# FOREST LAKES FILING NO. 6

# CONSTRUCTION PLANS

PCD Filing No.:  
SF-20-027

EPC STORMWATER REVIEW COMMENTS  
IN ORANGE BOXES WITH BLACK TEXT

FOREST LAKES FILING NO. 6			
GRADING AND EROSION CONTROL PLAN			
DESIGNED BY	MAL	SCALE	DATE 08/04/2020
DRAWN BY	MES	(H) 1" = 50'	SHEET 2 OF 30
CHECKED BY	(V) 1" = N/A	JOB NO.	1175.60

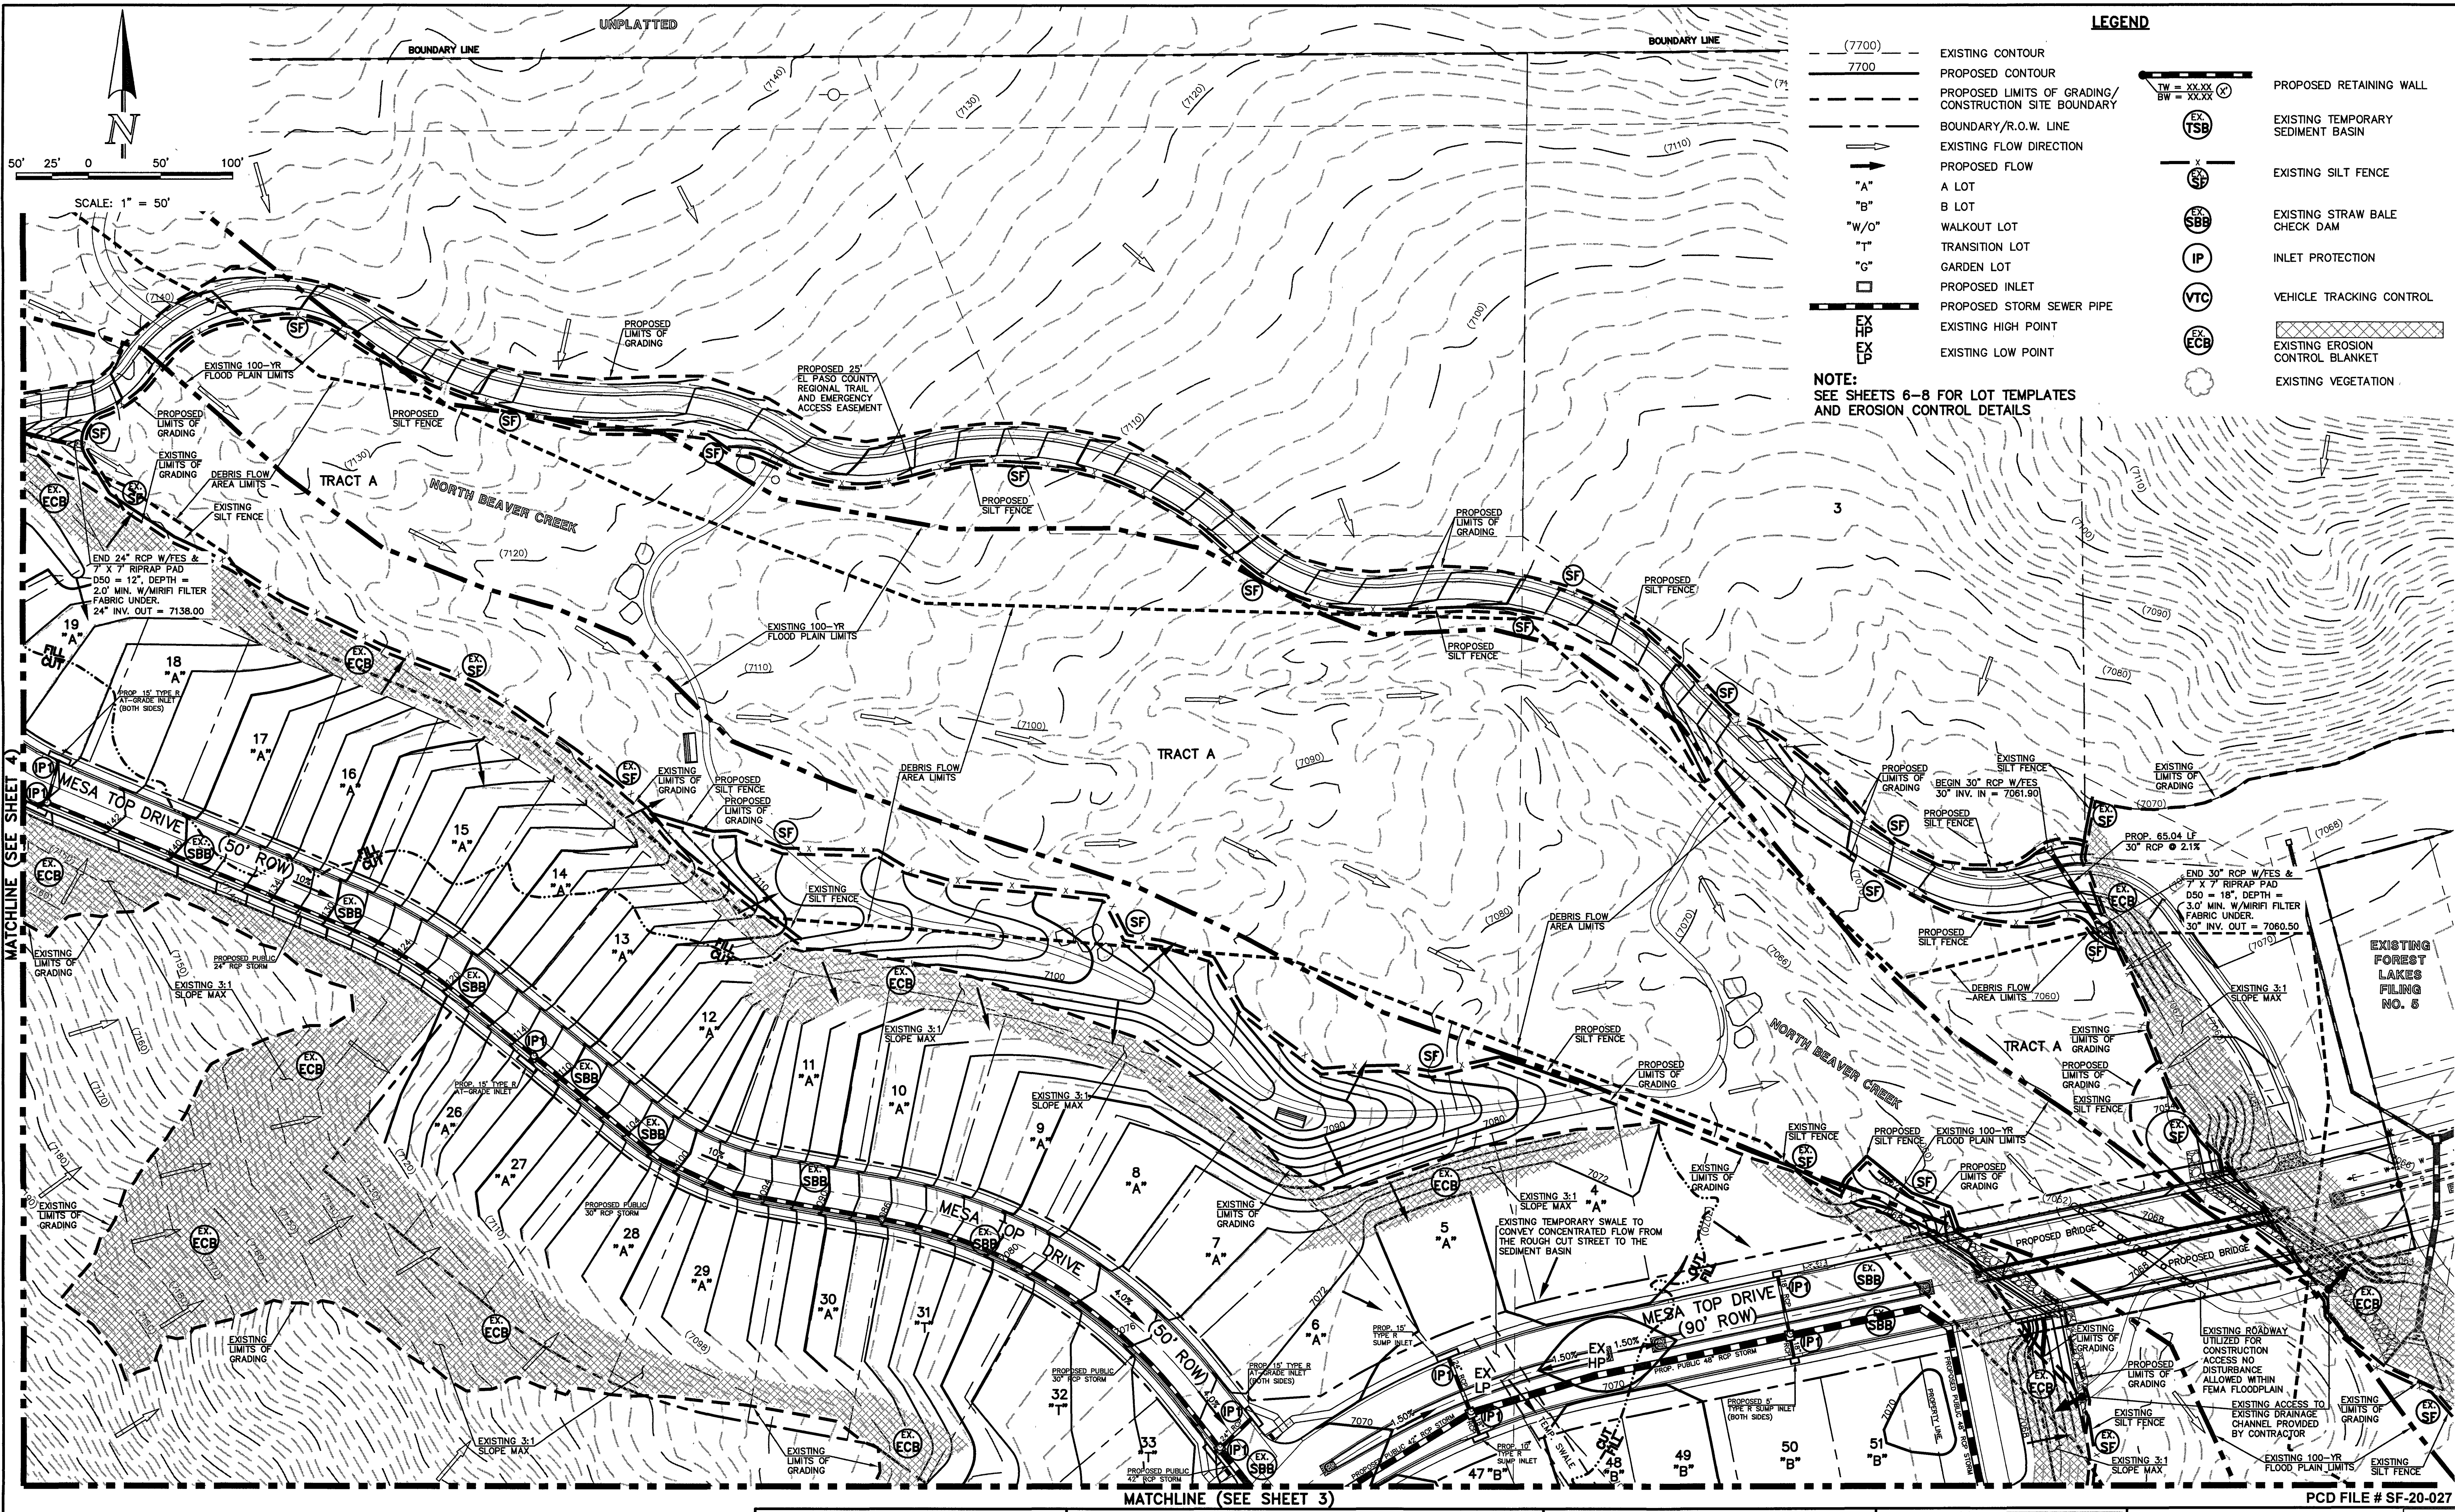
Checklist Item H - label Construction Site Boundary. If same as Limits of Grading, revise Legend text to say: "Proposed Limits of Grading / Construction Site Boundary"

SWMP Checklist Item 17d - Delineate areas of cut and fill

Show location of CWA, staging areas, and designated stockpiles. Or note that these locations are TBD.

Revise to match in type shown in Legend (typ)
